CLEAR VIEW INDUSTRIAL PARK, FILING 2A

GRADING, STORM AND EROSION CONTROL PLANS

EPC STORMWATER REVIEW COMMENTS
IN ORANGE BOXES WITH BLACK TEXT

SHEET TITLE:
EXISTING SITE PLAN

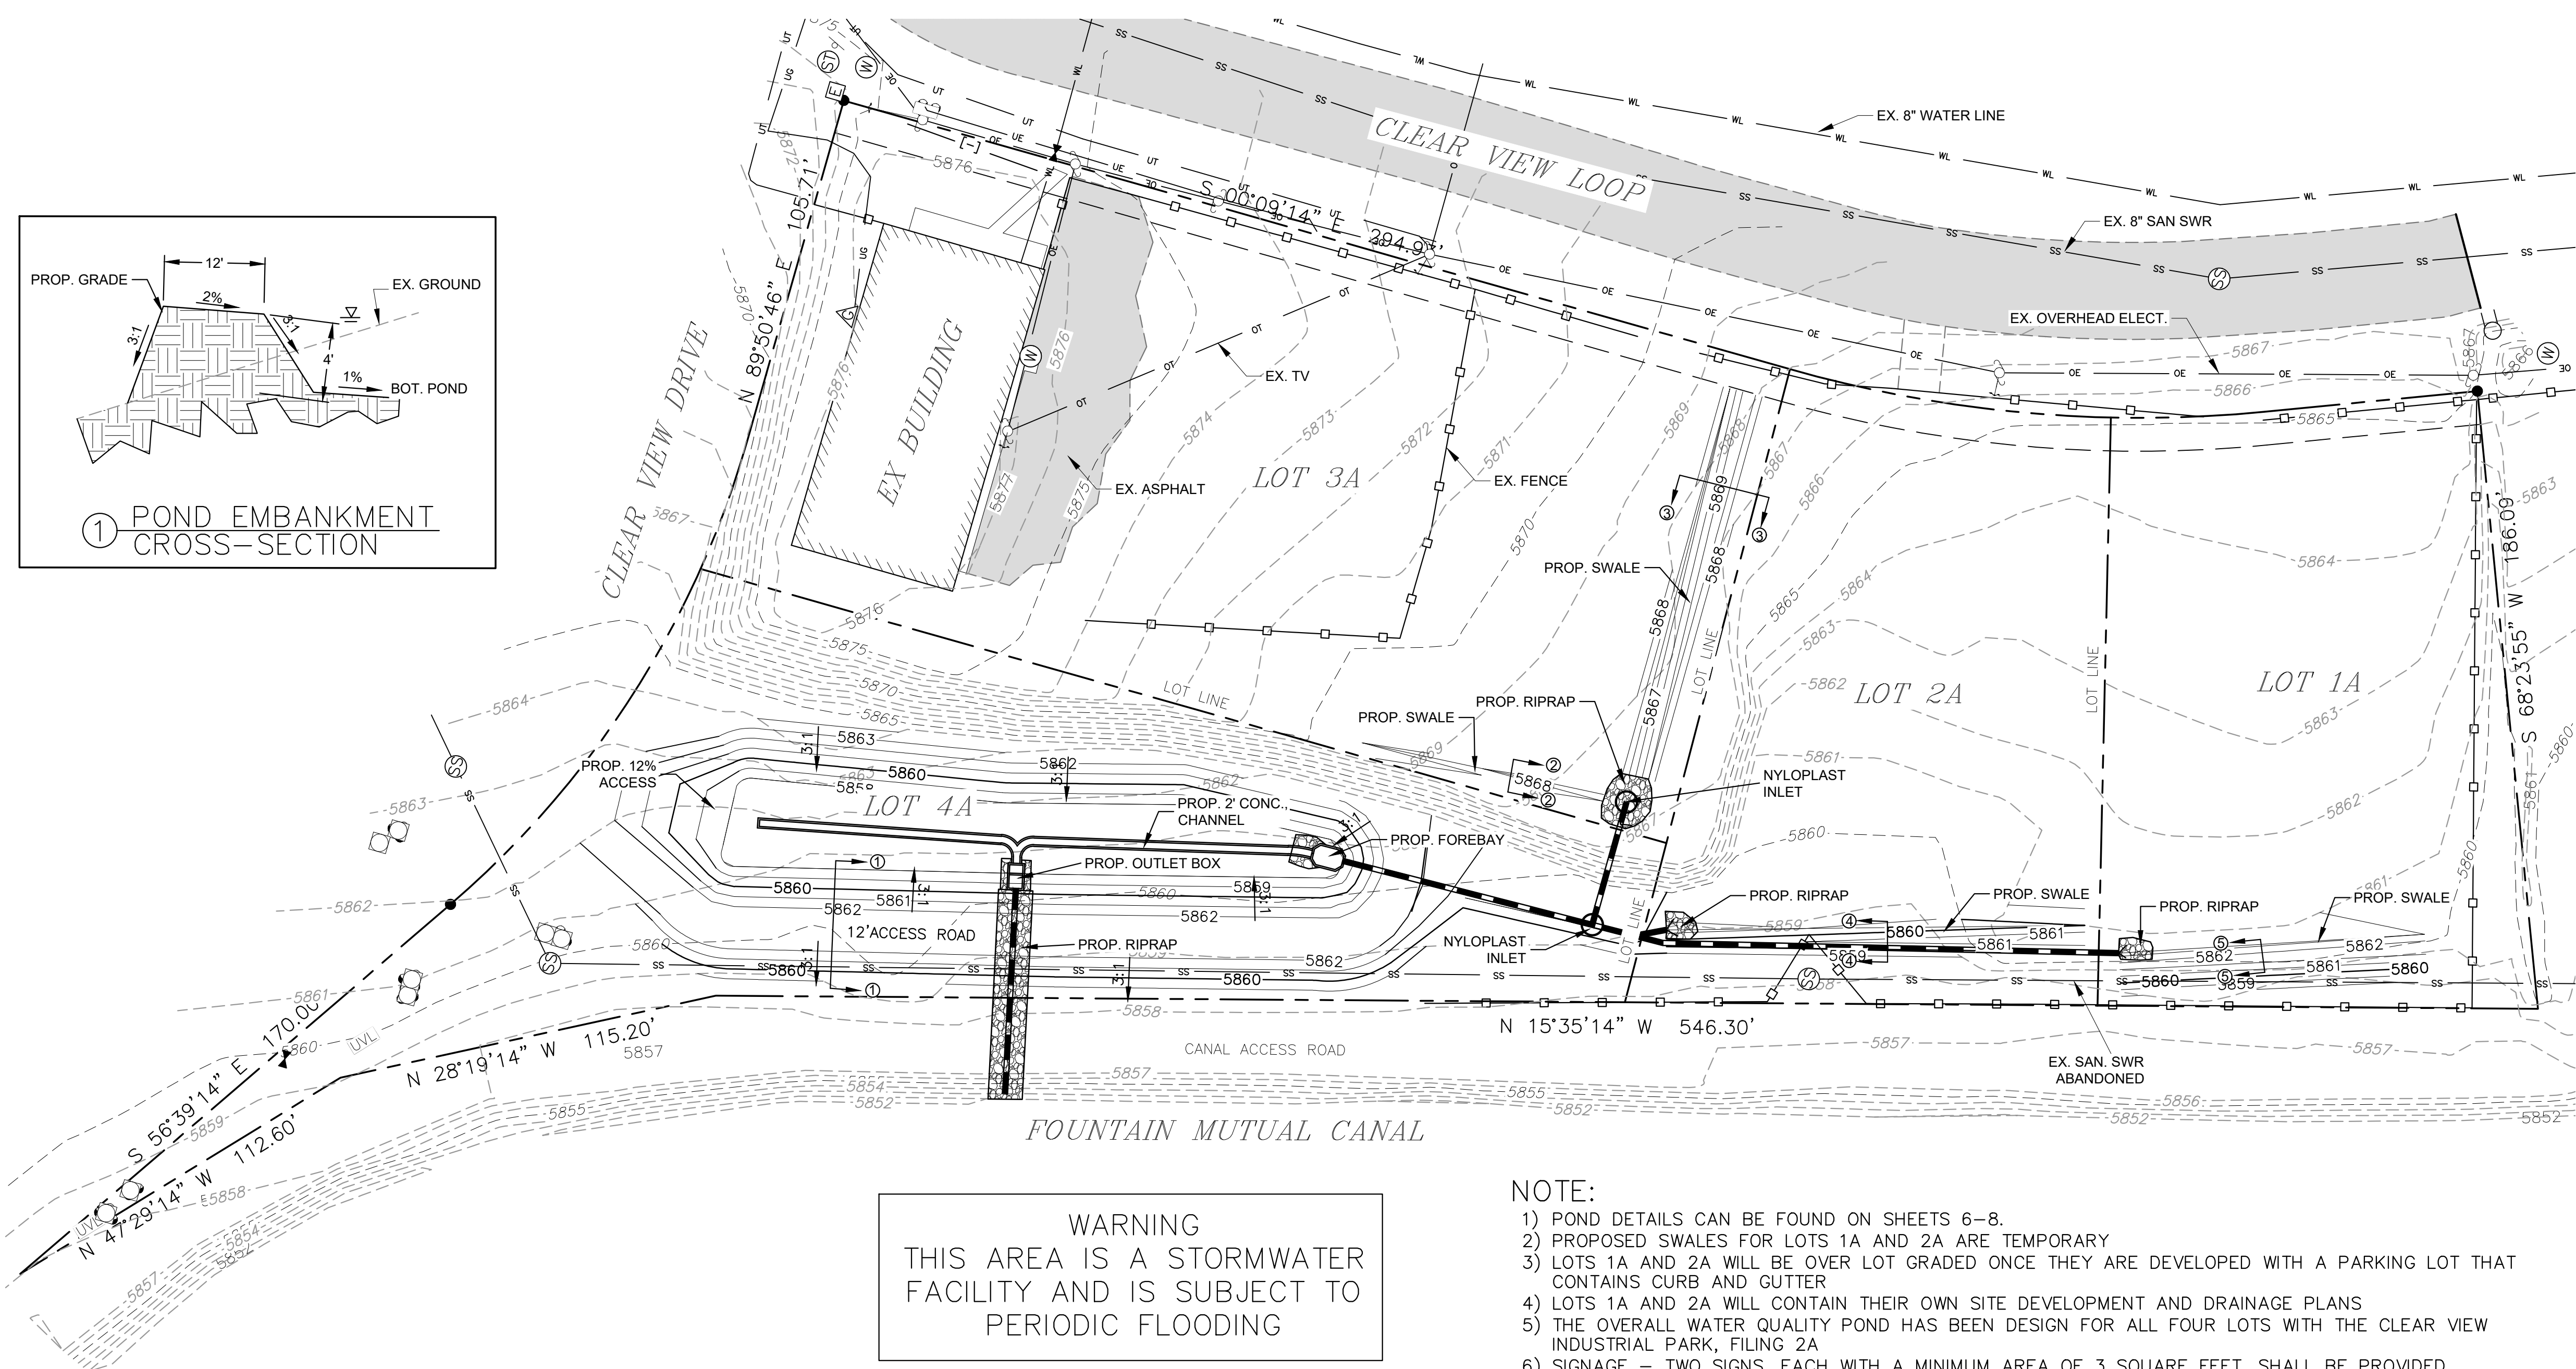
Use proposed replatted lot names to avoid confusion about lots.

delete notes 1 & 2.

Update notes to remove inconsistencies. Lot 2a and 4a are combined to a single lot, therefore the pond within lot 2b will become a drainage easement.
